From: Laura Gibbons <Laura.Gibbons@arun.gov.uk>
Sent: 19 April 2022 14:25
To: Planning.Responses <Planning.Responses@arun.gov.uk>
Cc: Simon Davis <Simon.Davis@arun.gov.uk>
Subject: RE: Planning Re-Consultation on: AL/28/22/DOC

Engineers Comments Regarding Condition 10

Application No: AL/28/22/DOC

Description of Works: Approval of details reserved by condition imposed under AL/20/21/PL relating to condition 10-surface water drainage. Decision due 28.04.22

(1:100)

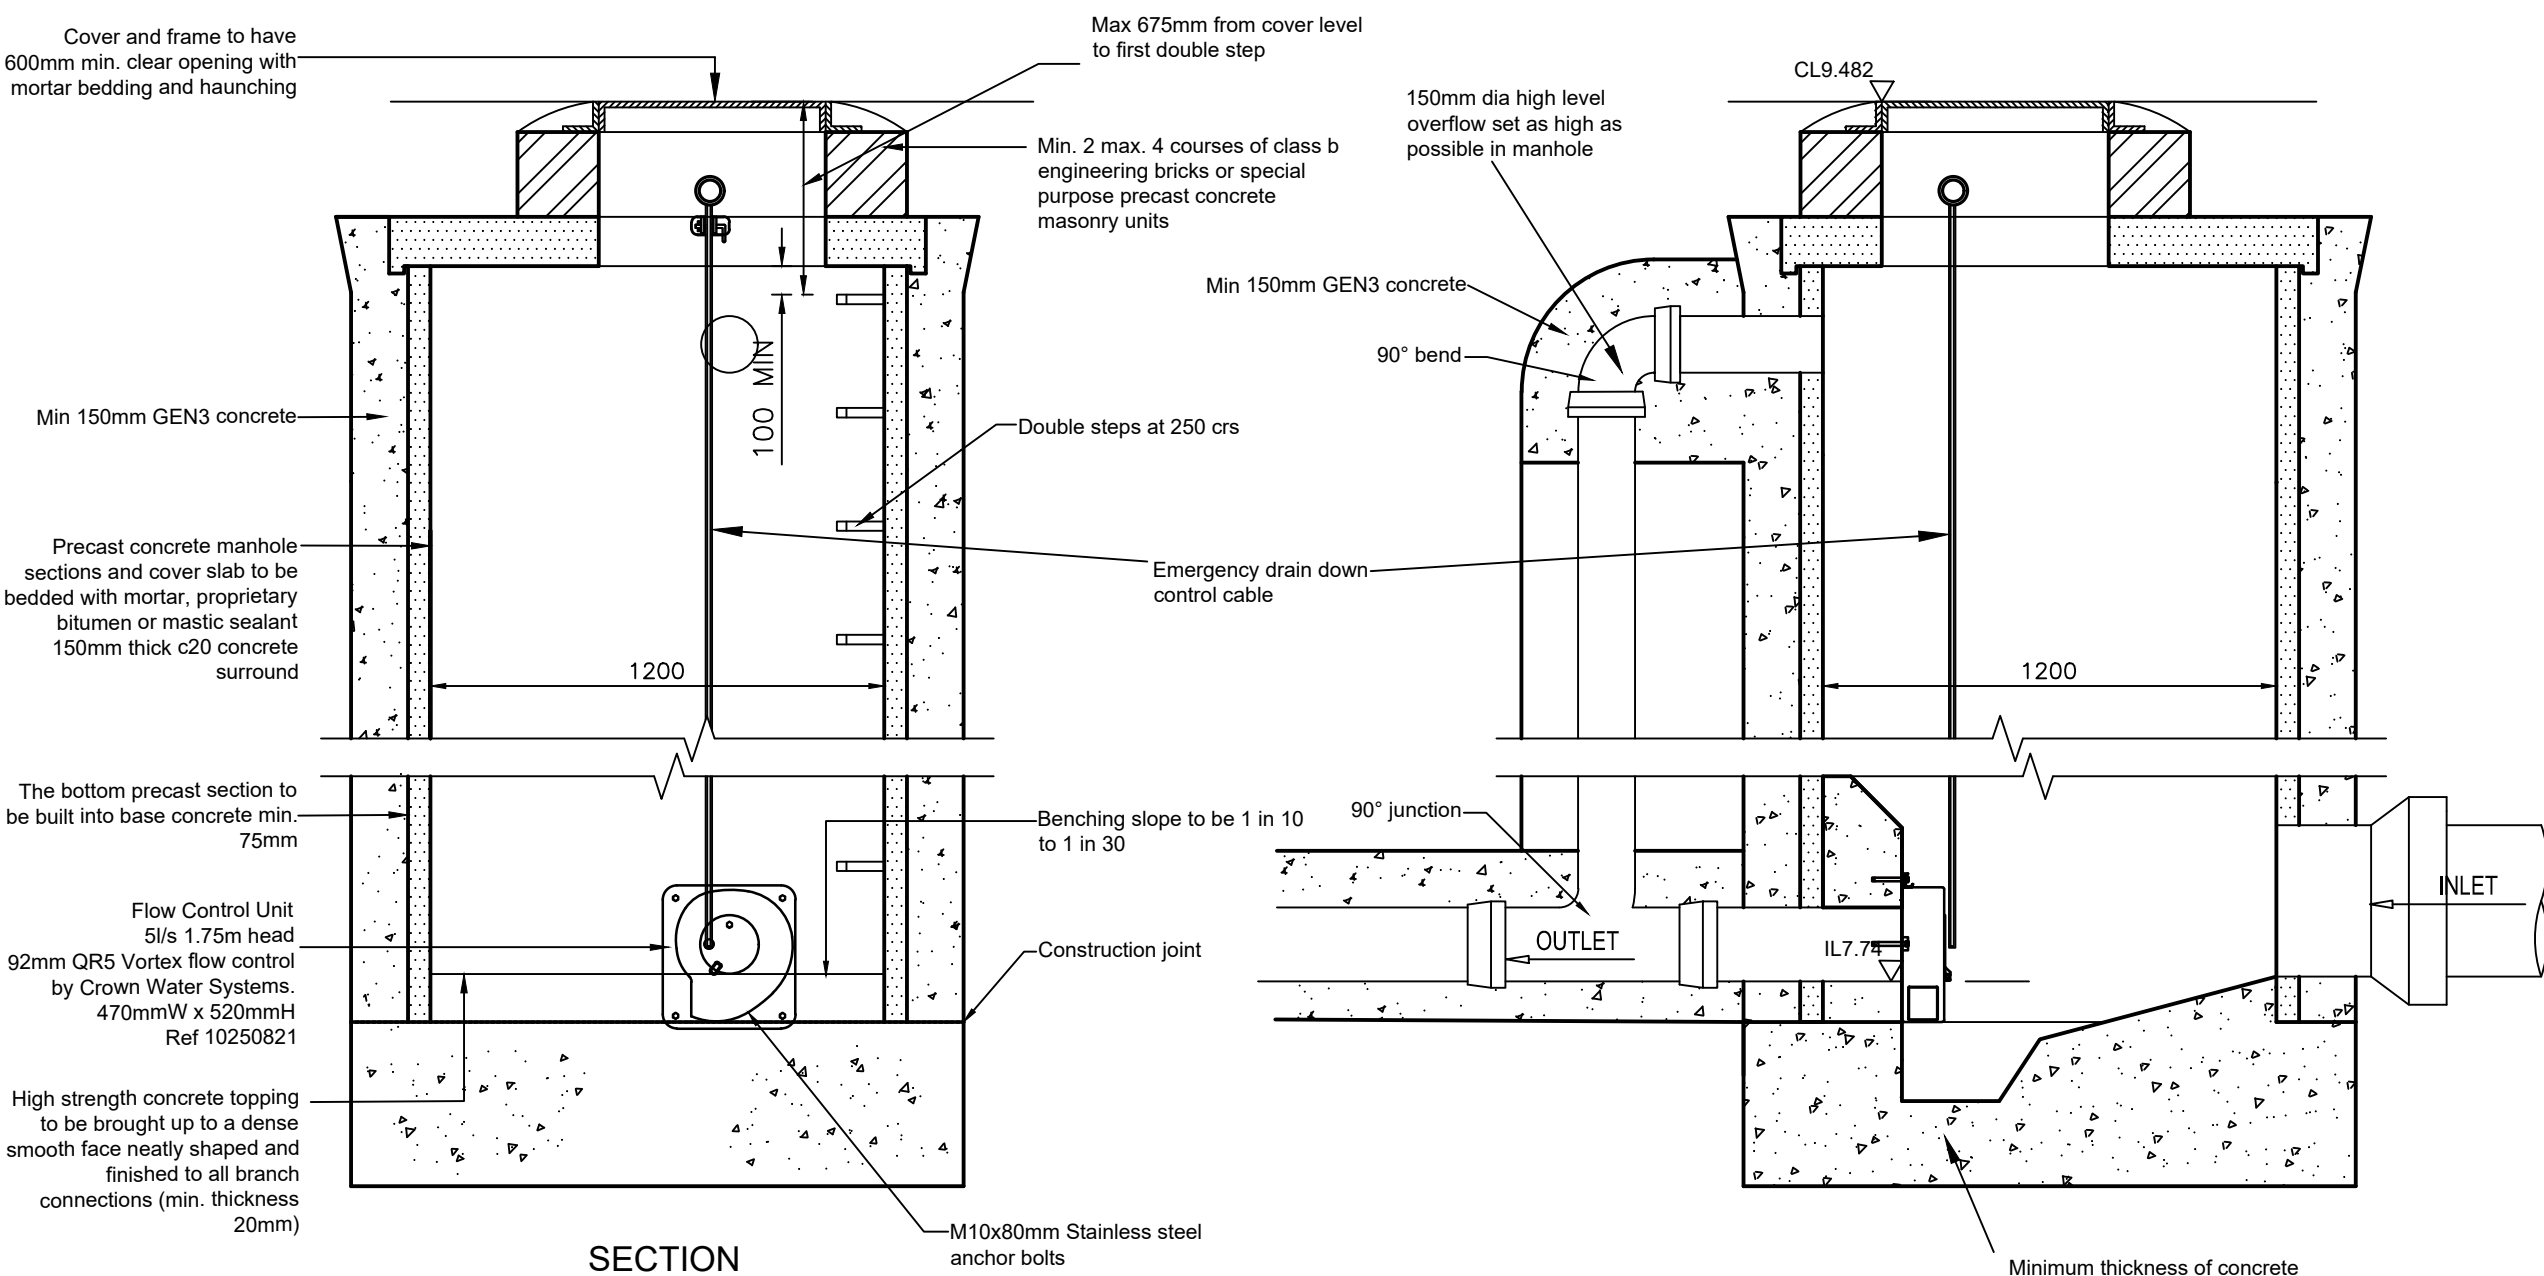
12. Please provide flotation calculations for cellular storage and attenuation basin. *Calculations provided, however no groundwater data near basin. Assumed depth of groundwater requires discussion and agreement.*

16. Please provide construction detail drawings of permeable paving. *Okay.*
17. Please provide two perpendicular cross sections of the basin, please detail liner, topsoil depths, etc. on construction detail drawing. *See comment 12.*

ACCESS ROAD CONSTRUCTION
DETAIL C
(PERMEABLE PAVERS)
(FOR FREQUENT COMMERCIAL VEHICLES)
(Scale 1:20)

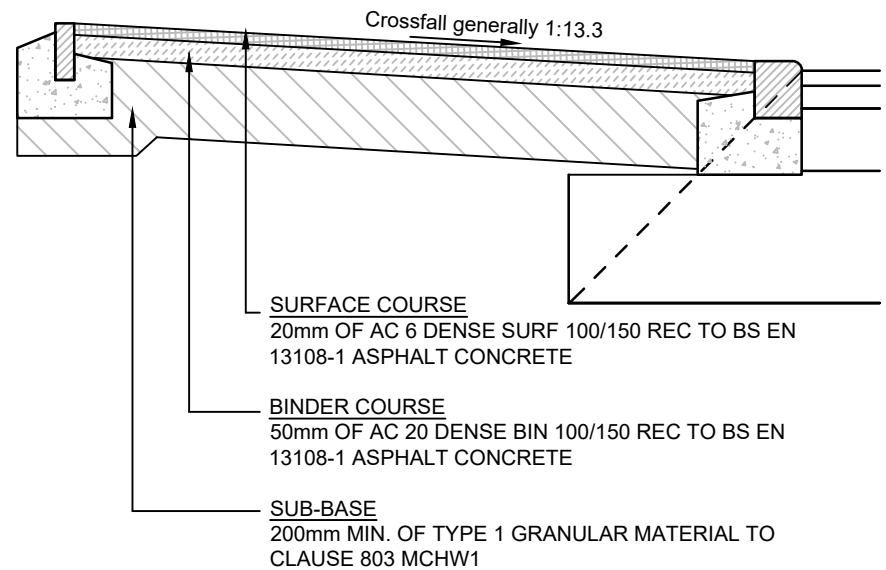
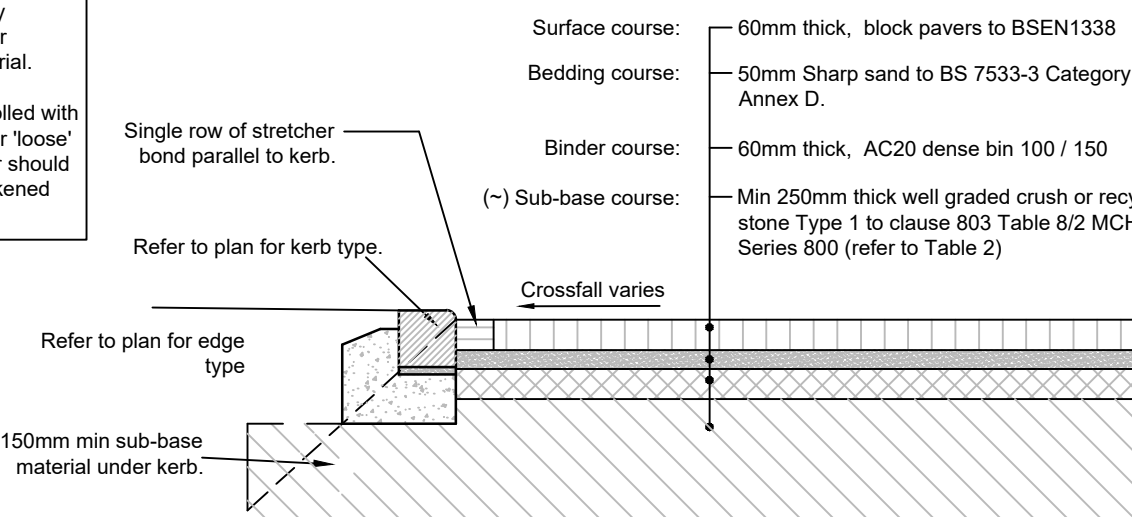
8. Please provide manholes on the points of connection into the main network from pipes serving 2 or more dwellings. *Okay.*
9. Please clearly label finish and formation level of all permeable paving areas. *Detailed.*
